25 Kent St, Permit #2396

Drawing file: 1. Original Plans / Porch Plan.pdf

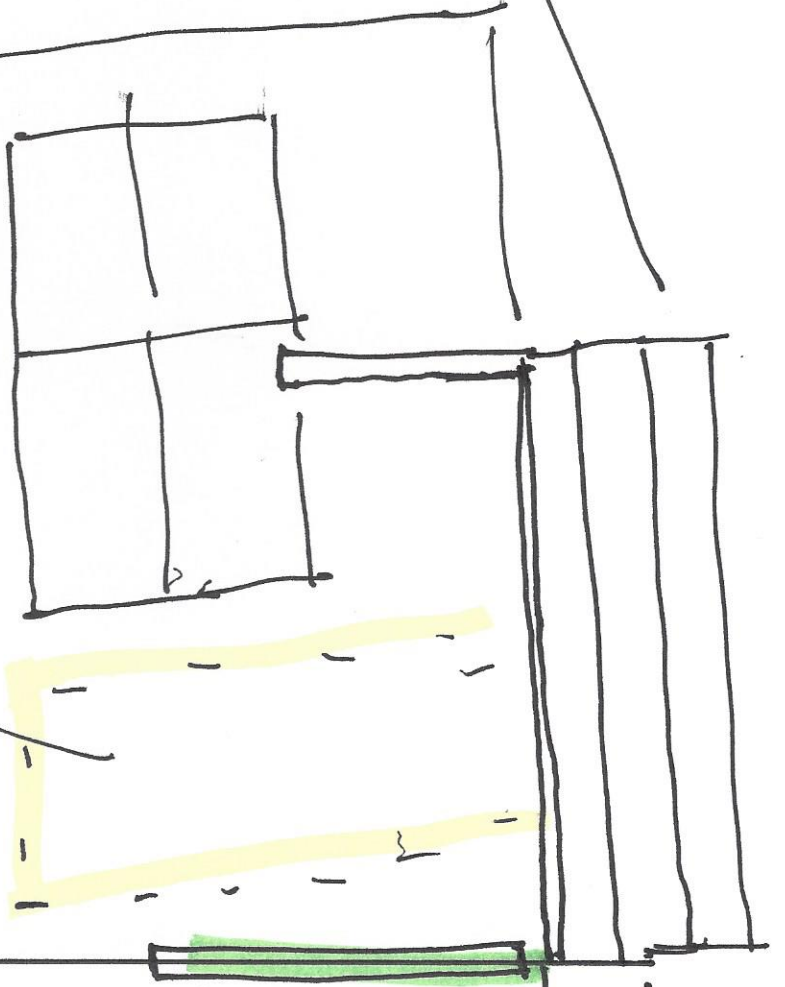
Hi Nate,
Can you help me answer the questions below?

Installing 3, 8' Ivl's with double jacks for new cased opening. Three risers drop in elevation from kitchen down to sunroom.

Rebuilding existing porch with new framing and new decking, slight change in elevation, keeping existing foot print .
remove old entry door in sunroom, install new entry door left of porch using original porch lay out to access new door.
